October 17, 2023

My name is Diane Berge and my husband and I own the property at 1061 FS Rd. 4517 in Granite Creek. I am strongly opposed to the Fowler Creek Guest Ranch CU-23-00003 for many reasons and feel it will be very detrimental to the Community, the environment and wildlife. These comments are regarding my concerns about Noise from this proposed development including their Exhibit 6, Surrounding Property Review, Exhibit 11, Impact of Noise on Surrounding Properties, and their Map (exhibit 11a?).

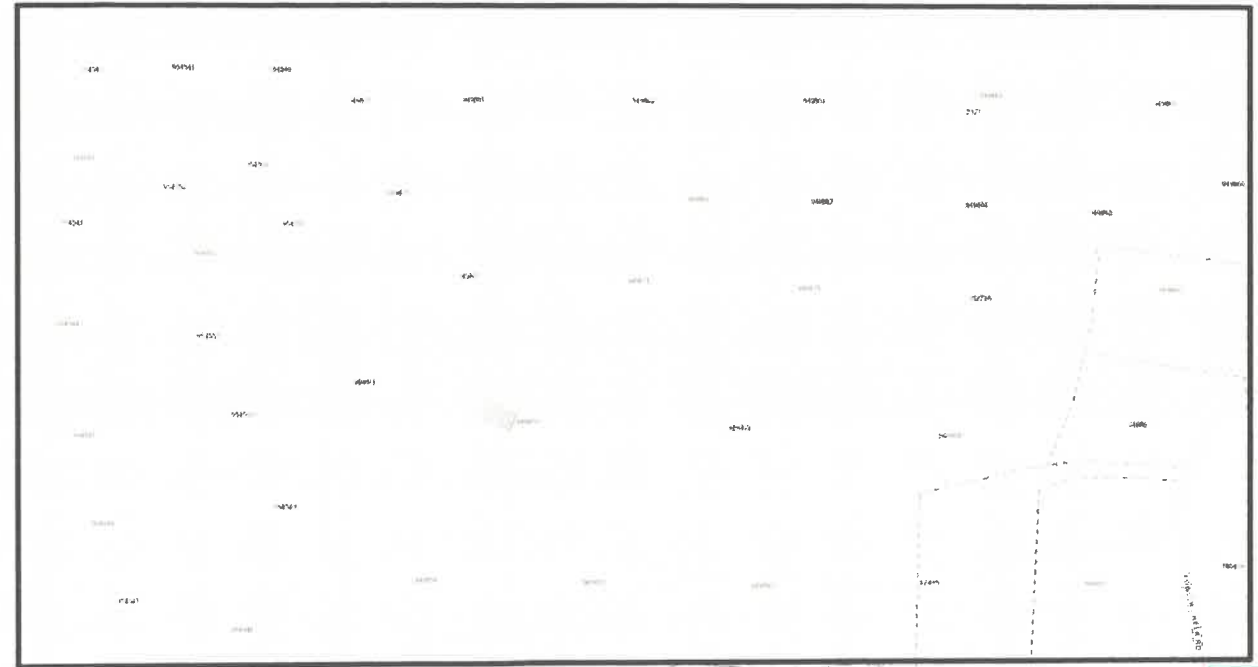
They state (exhibit 11) the closest adjacent property center is greater than 400 feet away from the closest property so noise isn't a problem. This is flawed logic and an oversimplistic and an unrealistic assessment of noise and also not consistent with my experience in the area and how the noise carries.

Within 84 Acre Parcel: For noise generated within the 84-acre parcel, the "Property Center" should not be the reference point here, it should be where the noise is coming from. By allowing snowmobiling within the 84 acres, we will have a constant, moving noise sources that will disrupt the peaceful character of the neighborhood. For example, kids could be riding that perimeter trail for hours each day, all within the property with no restrictions. People will use their snowmobiles to go from the BARN to the Residential habitats, viewing platforms etc. And they will be used for ingress & egress as well. Lots of noise, all day long. Snowmobile noise carries and there is no way to screen it. Who will prevent snowmobilers from taking a night ride? The developer states they plan to disallow use of wheeled recreational vehicles within the property, that is good. This commitment should be a Condition of Use, not a false promise that is unenforceable. Other non-recreational vehicle noise from within the parcel will also be an impact. A large 200-person event held in the "Barn" which is

Parcel 17437 will also have extremely high impact, just feet from the development boundary. The map I've attached also shows the close proximity of others homes to this development, mine among them. These properties will be the most impacted for noise in the area of FS Rd 4517, not all of the were even listed on their Exhibit 6.
